Application Reference: 2025/0367

Site Address: 34 Norwood Drive, Brierley, Barnsley, S72 9EG

Introduction: This application seeks full planning permission for the erection of 1.5 storey side/rear extension incorporating front dormer, erection of front porch/hallway extension and creation of additional hardstanding for parking to the front of the dwelling.

**PROPOSED GROUND FLOOR
LAYOUT SCALE 1:50**

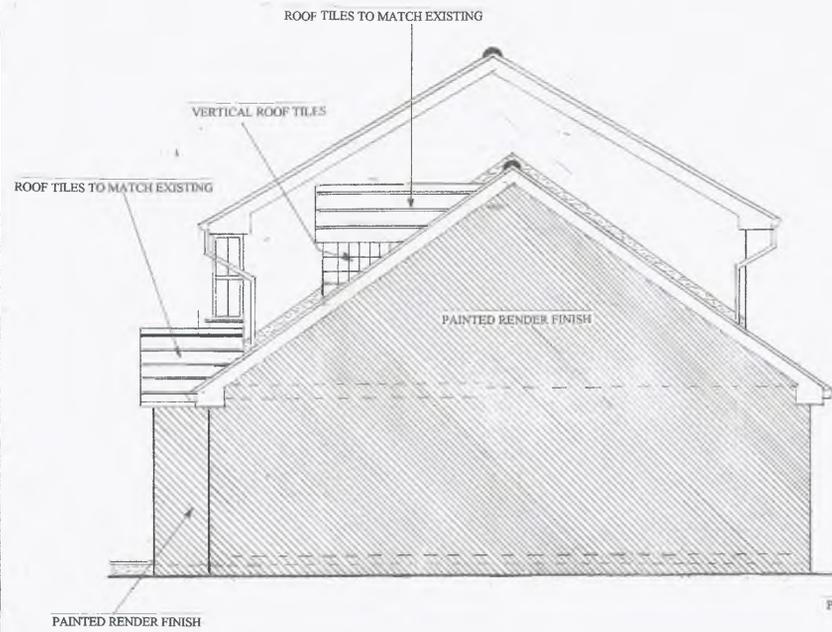
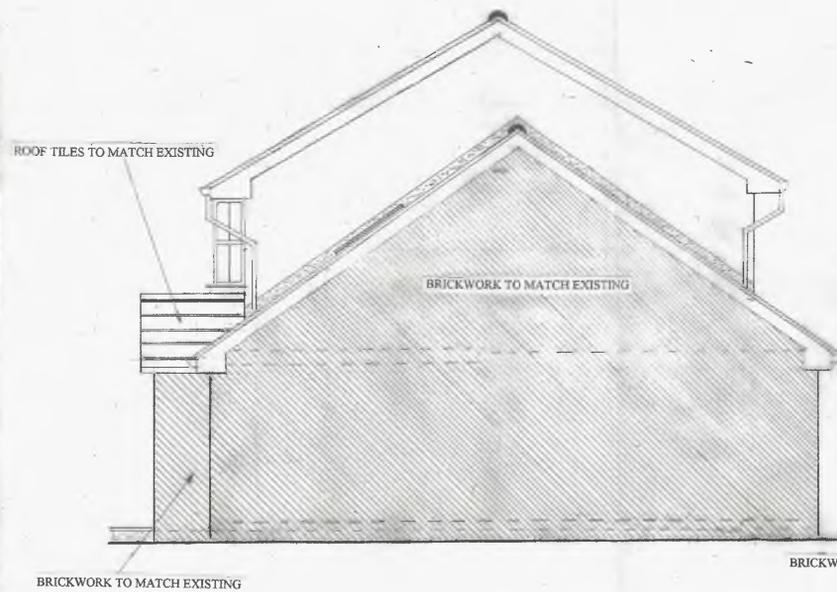
The proposal increases the number of bedrooms, with an additional ground floor bedroom and reduces the existing parking provision. To meet local policy requirements of a minimum of two parking spaces for dwellings with three or more bedrooms, an additional two parking spaces, which meet highways standards of a minimum of 2.5m x 5m are proposed within the front

garden. Highways have requested a condition which ensures the parking provision is completed prior to occupation of the extension. As a result of the additional parking, the proposal would meet local policy requirements and subject to the separate approval of Street Works for the dropped kerb, there would be no impact on highway safety.

**PROPOSED FRONT ELEVATION
SCALE 1:50**

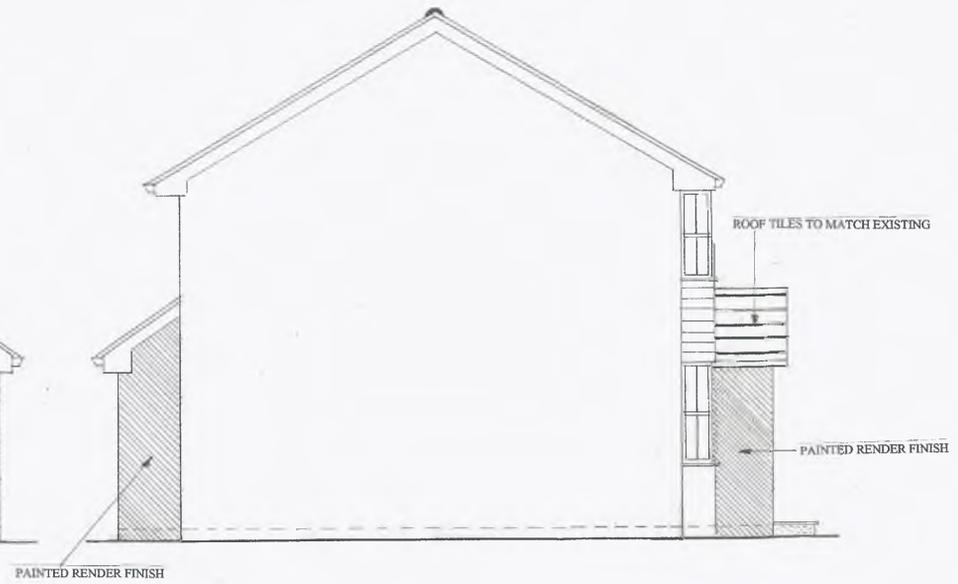
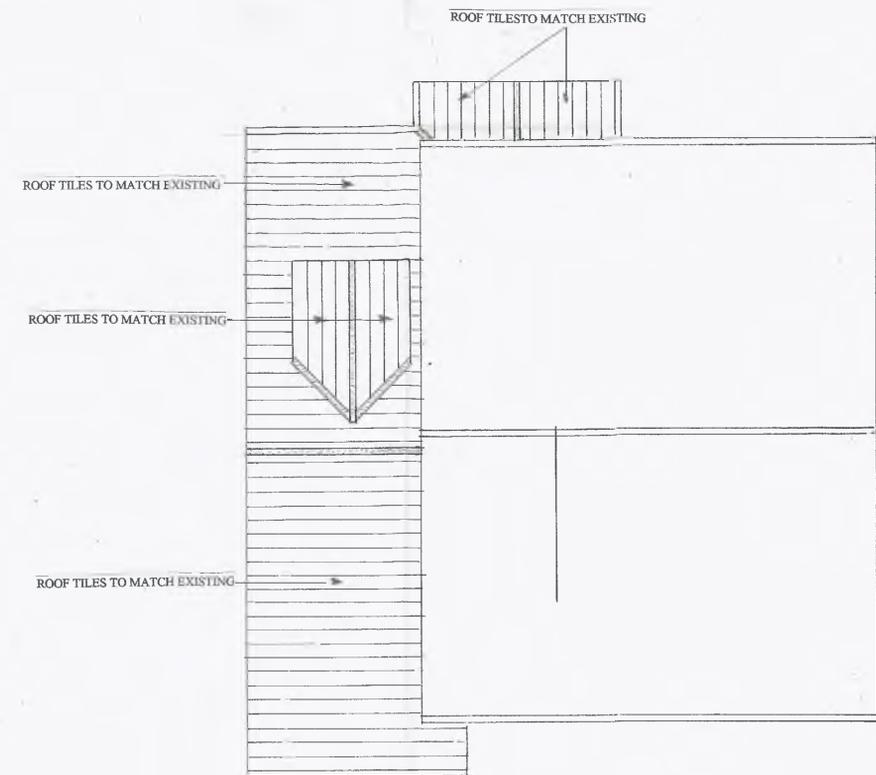
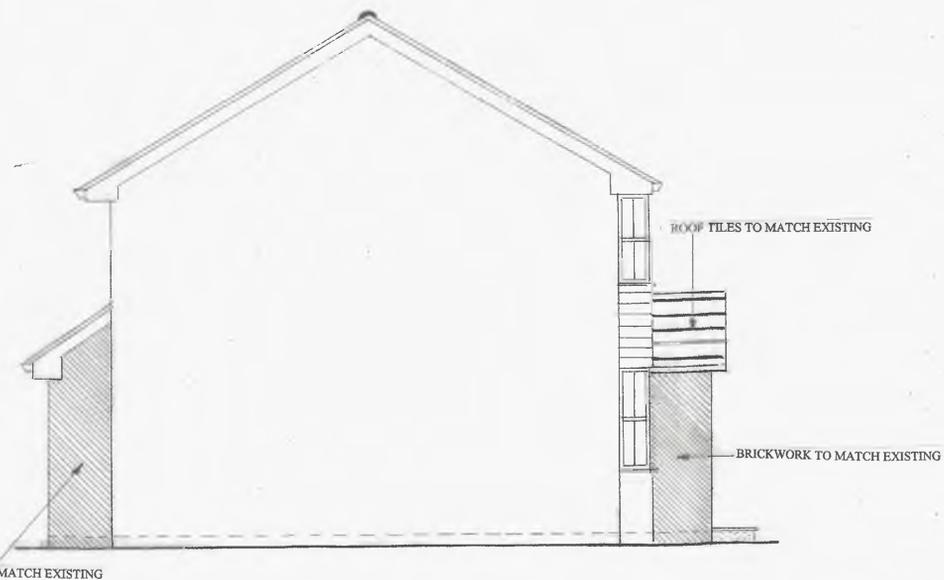
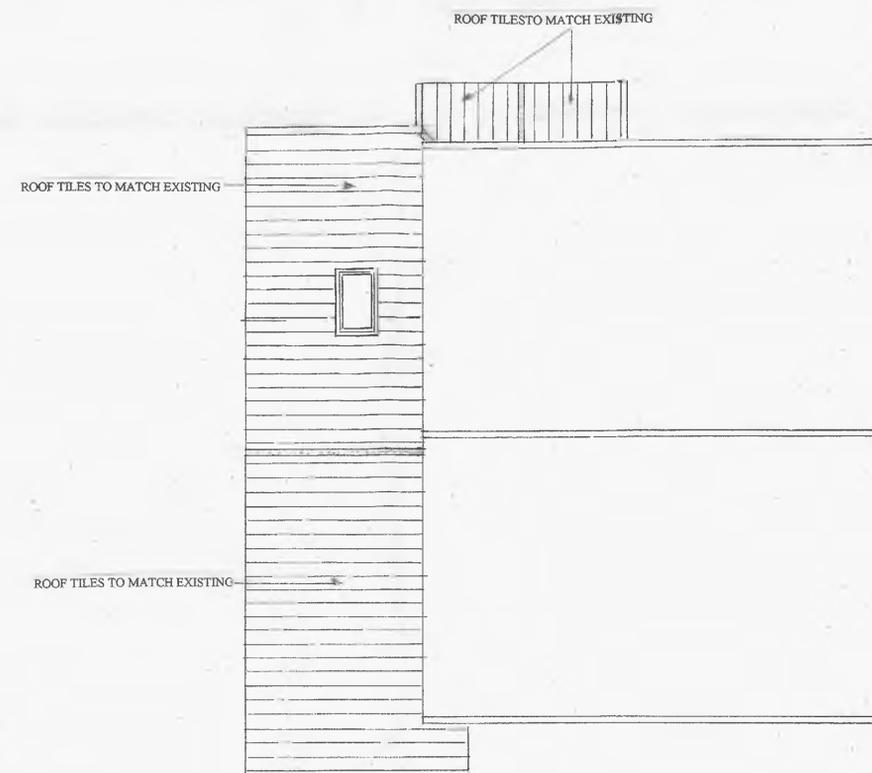
- Originally, a dormer window within the front roof plane of the extension was proposed, this has now been replaced by a Velux style roof window.
- Render, which would have been out of character with the dwelling and street scene was also originally proposed. This has been changed to matching brickwork to the original dwelling.
